## **H13-0524-24- S73 application to vary condition 2- approved plans and condition 5 timing of parking layout submission.**

**Planning permission was granted in 2024 for the change of use of No29 Pipwell Gate, Moulton Seas End from a residential dwelling (C3 use) to a children's home (C2 use).**

This application is made under S73 of the Act and seeks to vary 2 of the conditions imposed on the permission.

Scale: 1:100 @ A3 Date: 23/05/24  
Drawing Title: PROPOSED FLOOR PLANS  
Drawing No. 575SK02 Revision C  
ALL DRAWINGS ARE THE COPYRIGHT OF I-100 DESIGN

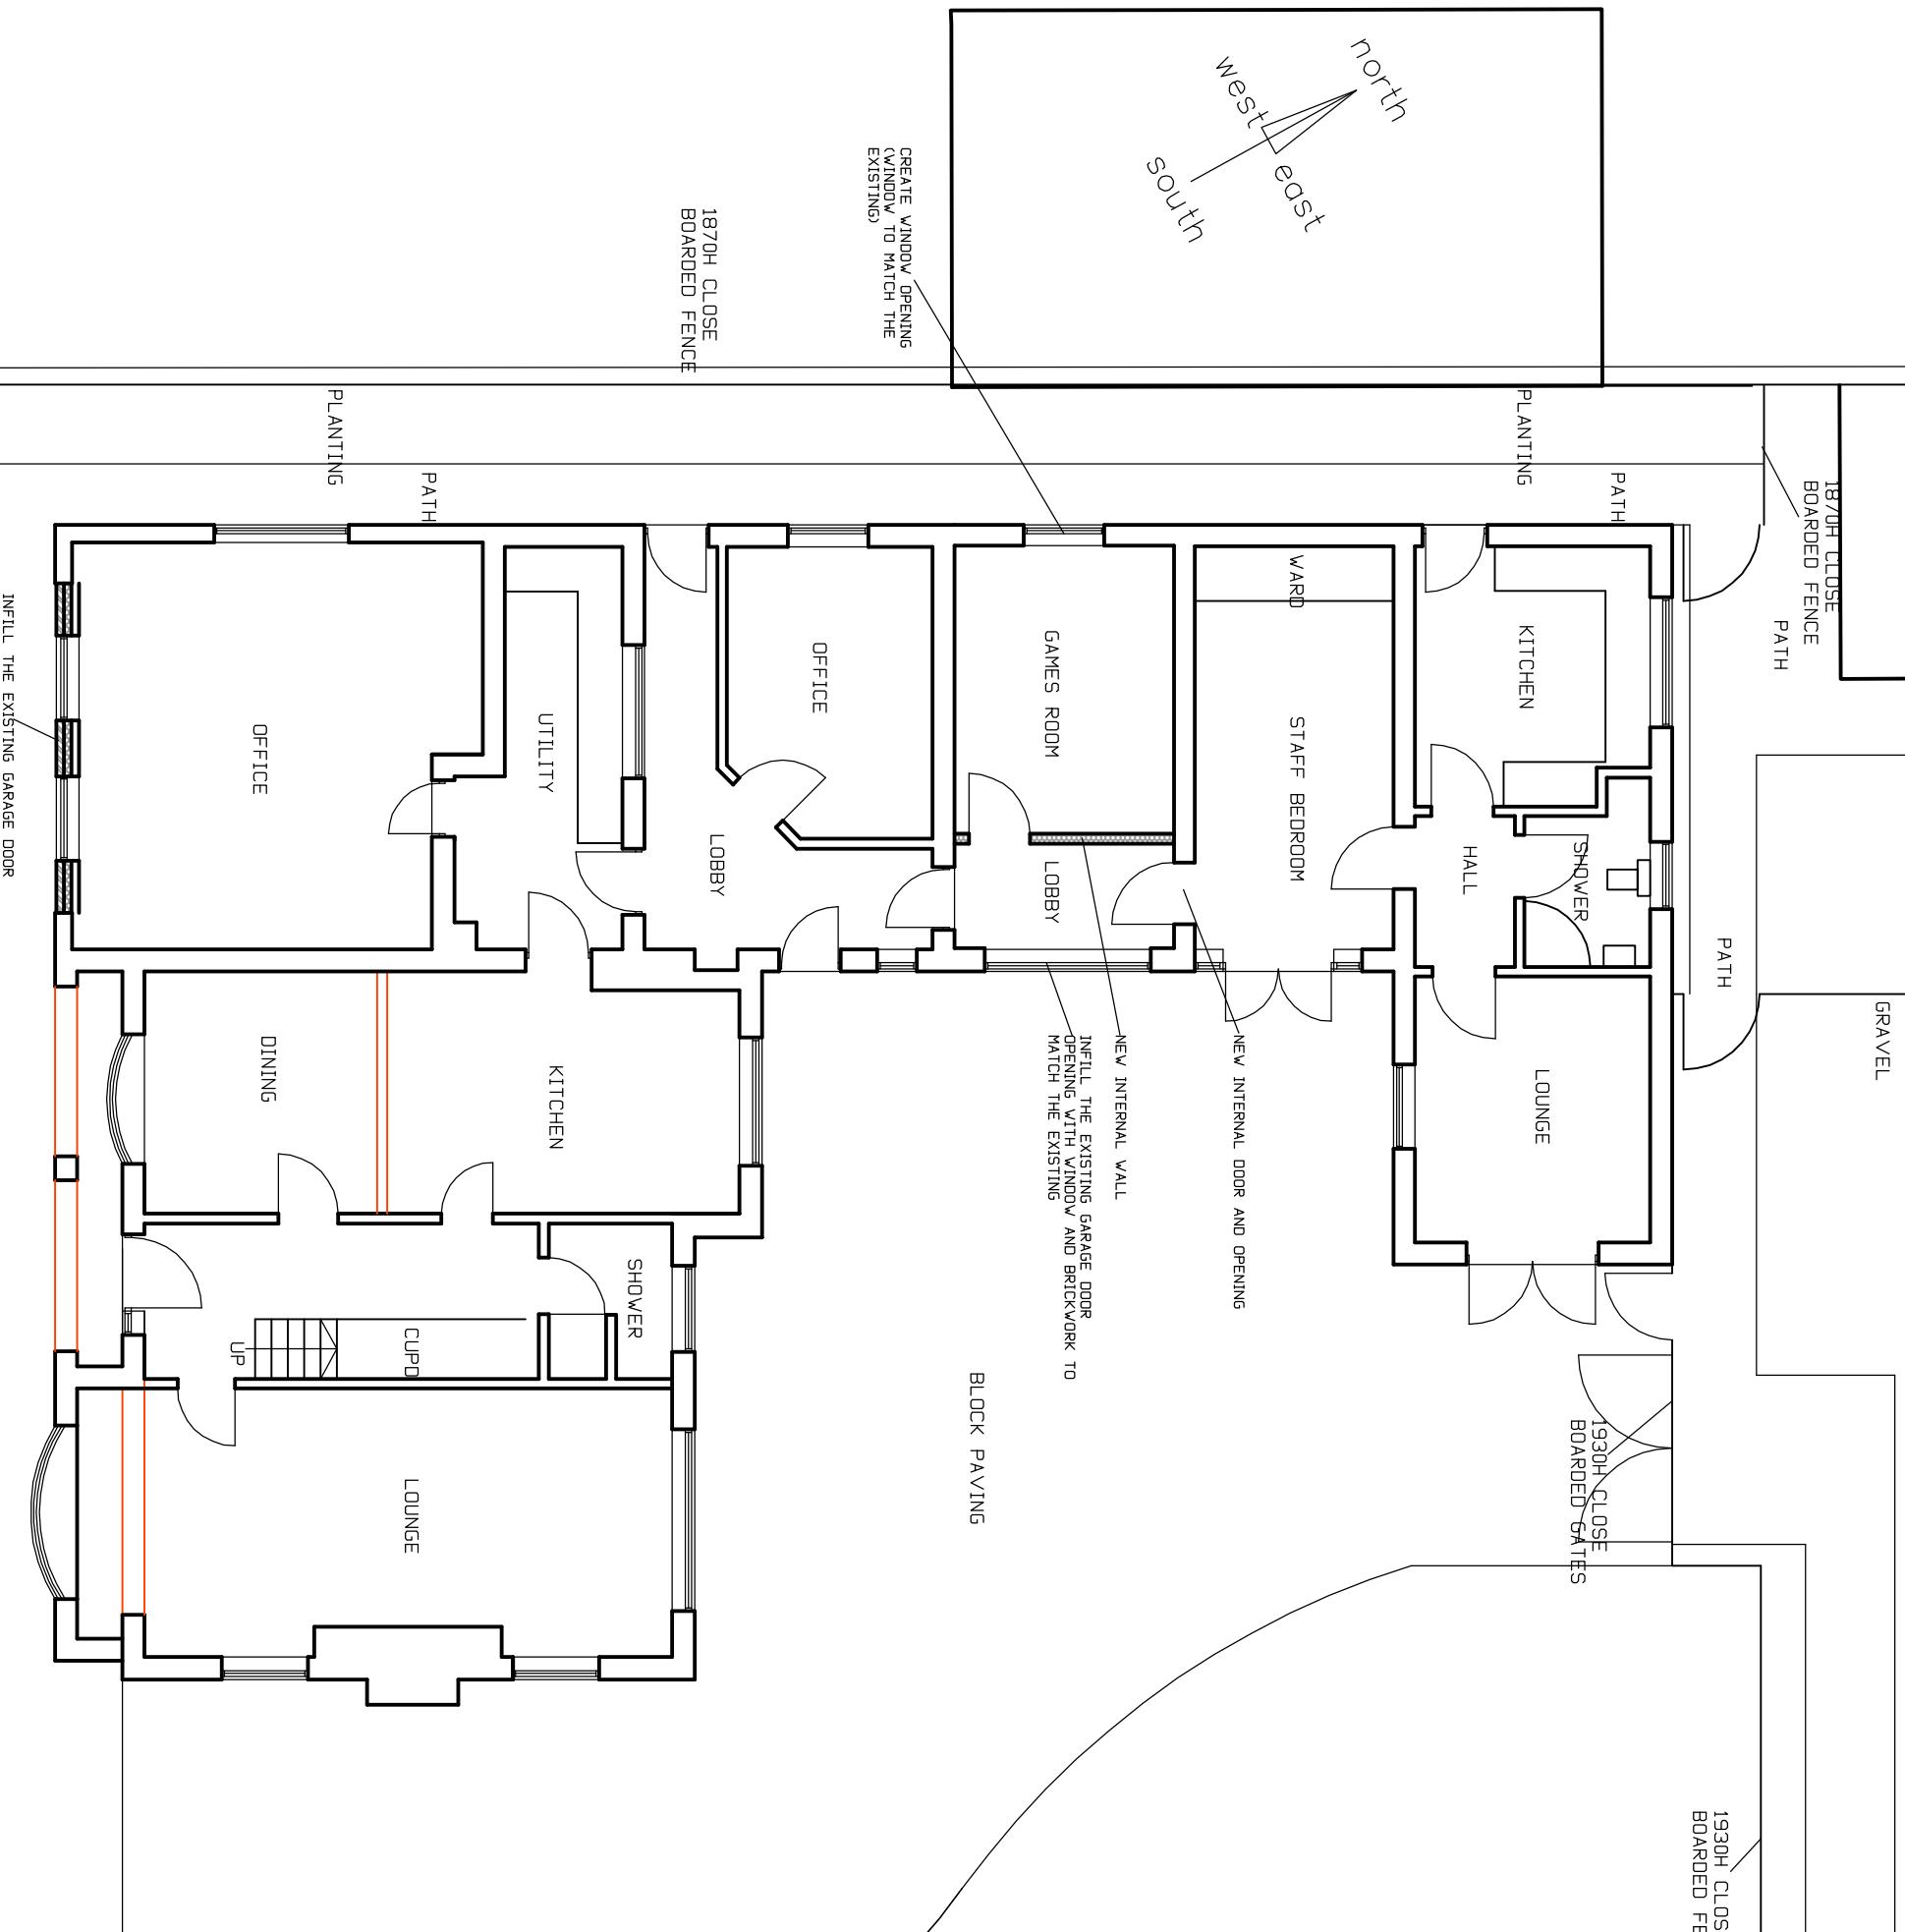
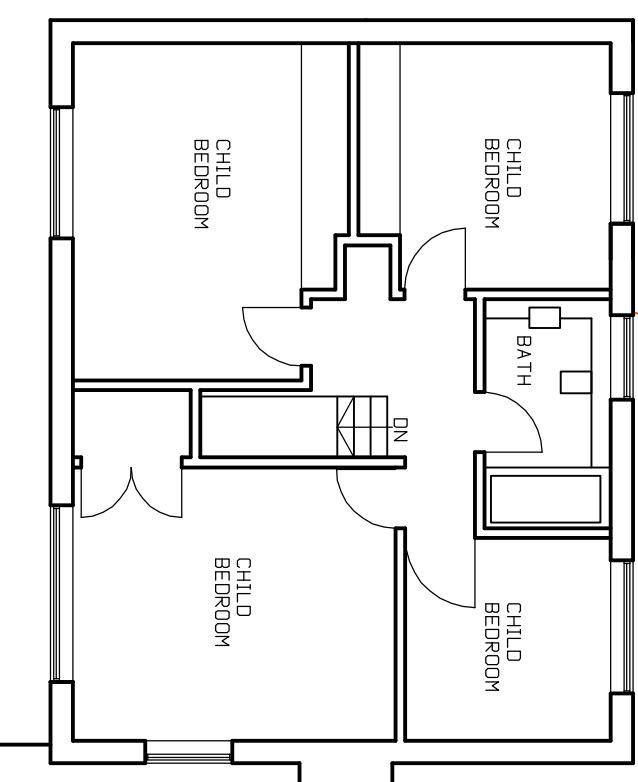
This application seeks to vary the proposed floorplan-575SK02, include proposed elevations and revise the site layout plan to enable the conversion of the front garage to a manager's office/ meeting room and the conversion of the integral rear garage to a games room and corridor to facilitate access from the carer's night accommodation to the main dwelling without needing to go outside.

Changes to floorplan are as shown on 575SK02 rev C.

- Replace 575SK02 Rev A with 575SK02 rev C.
- Replace 575SK03 with 575SK03 rev C.
- Add 575SK04 to approved plans.
- All approved documents in C2 to remain as previously approved.

Drawing No.: 575SK03 Revision: C

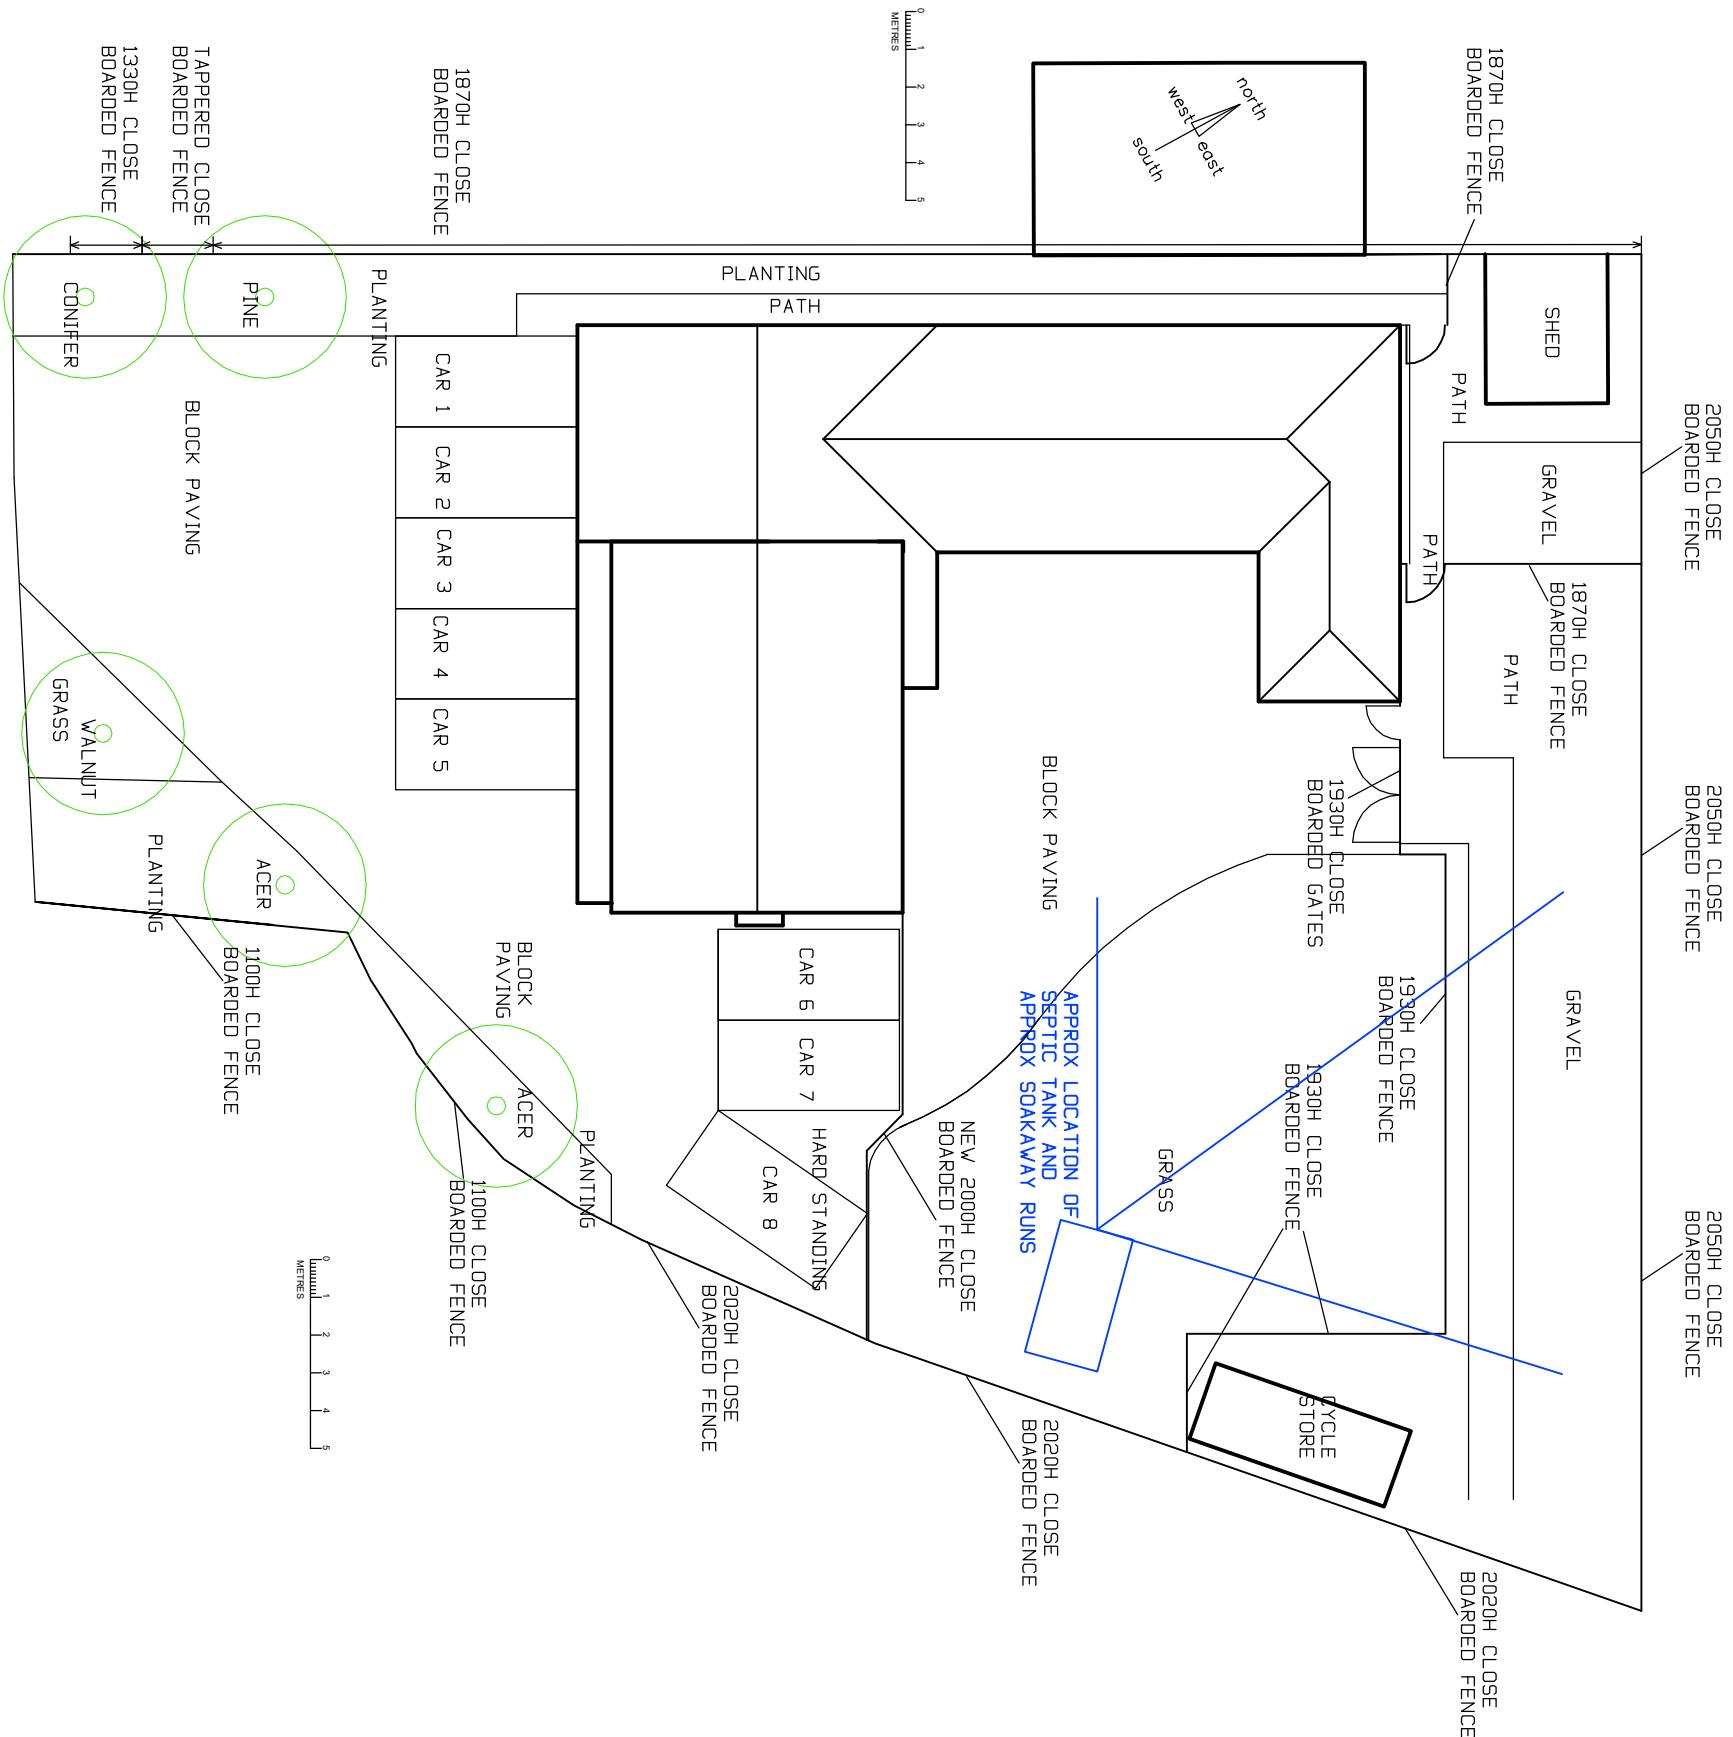
In converting the garage - one parking space displaced from garage (as shown on the approved plan) but this is relocated as shown on proposed parking plan and is preferable as all parking spaces are now accessible independently and users can access the site turn round and exit in a forward gear.

Cycle parking is also displaced from front garage to an existing shed to rear of the property- see layout plan.

Changes to site layout and new parking layout Proposed block plan and parking/ cycle parking plan 575SK03 rev C.

This shows the 8 independently accessible parking spaces with manoeuvring space as requested in relation to the previous permission.

***Prior to commencement of the care home use, the parking layout as shown on plan 575SK03 rev C shall be implemented in full and made available for use thereafter.***

575SK04

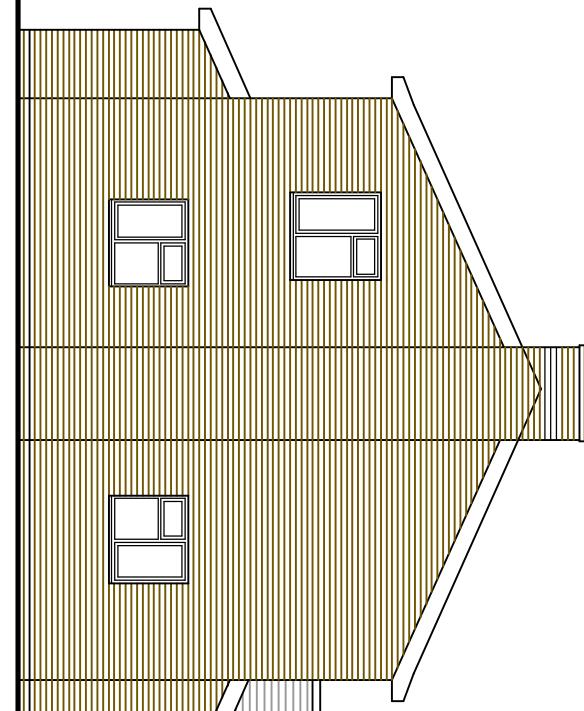
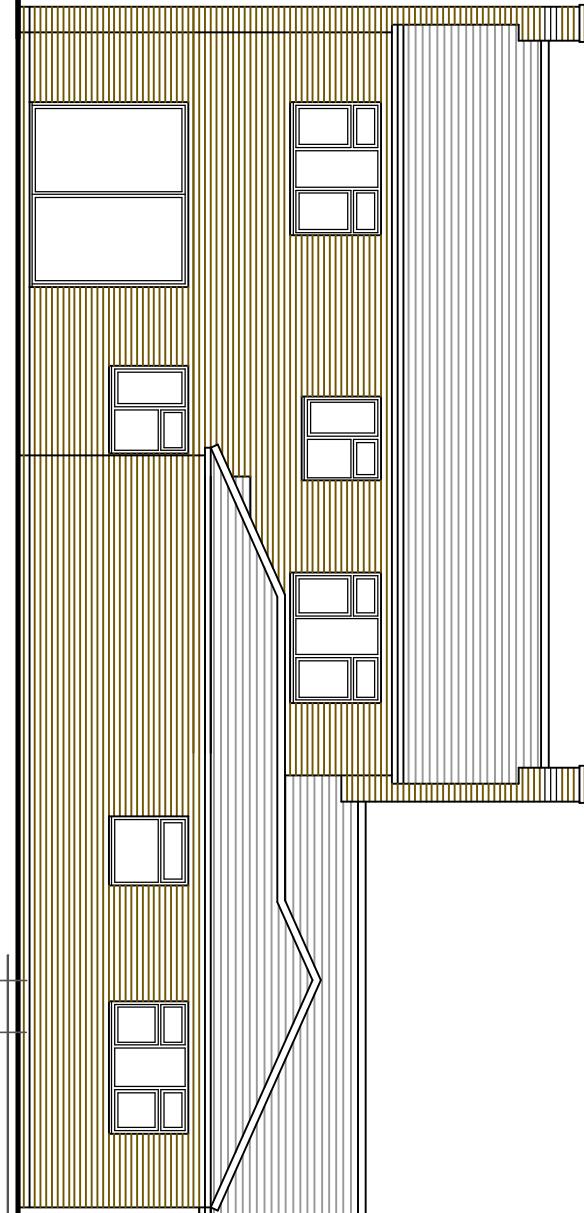
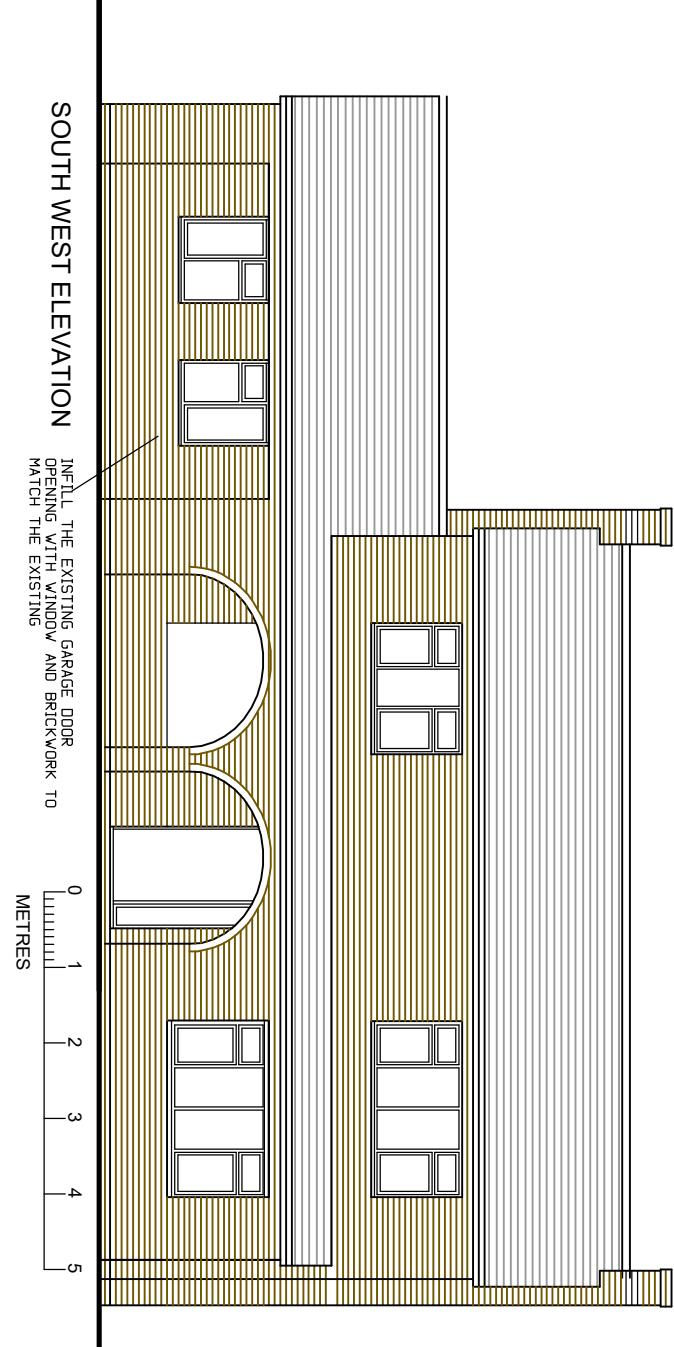
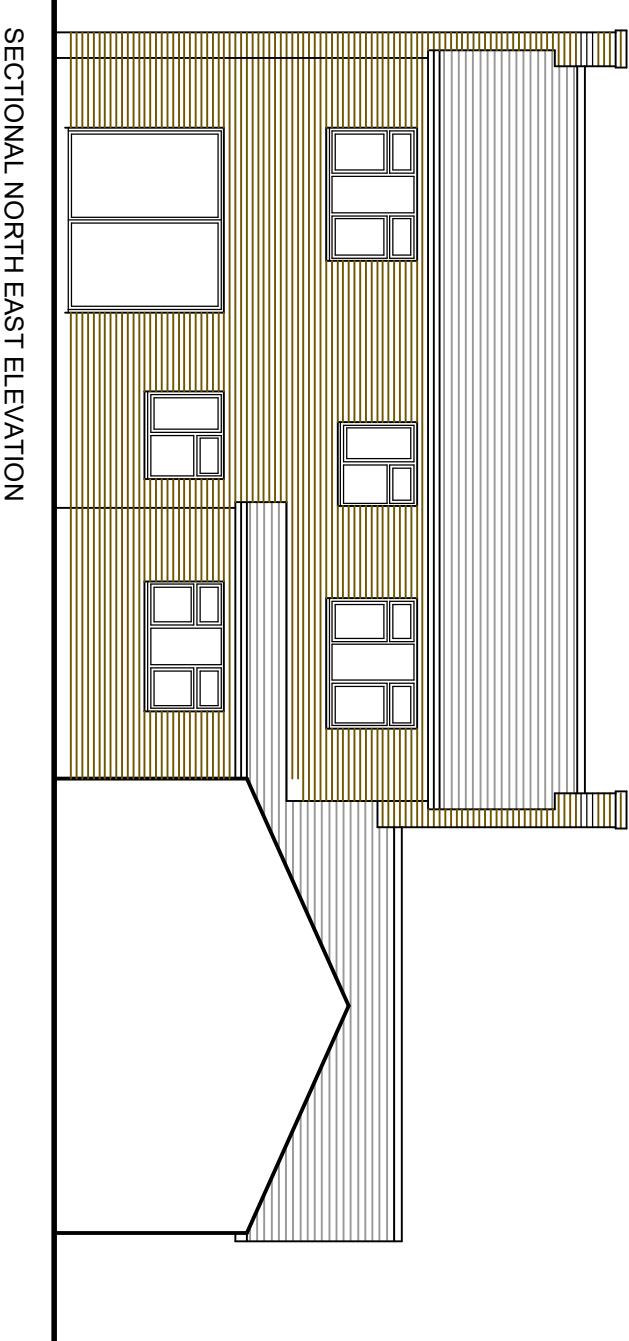
The external changes are limited to bricking up the garage door and insertion of windows to create an office, the bricking up of the garage door on the small integral garage and insertion of a window, the insertion of a window on the western elevation to get light to the games room. See plan 575SK04.
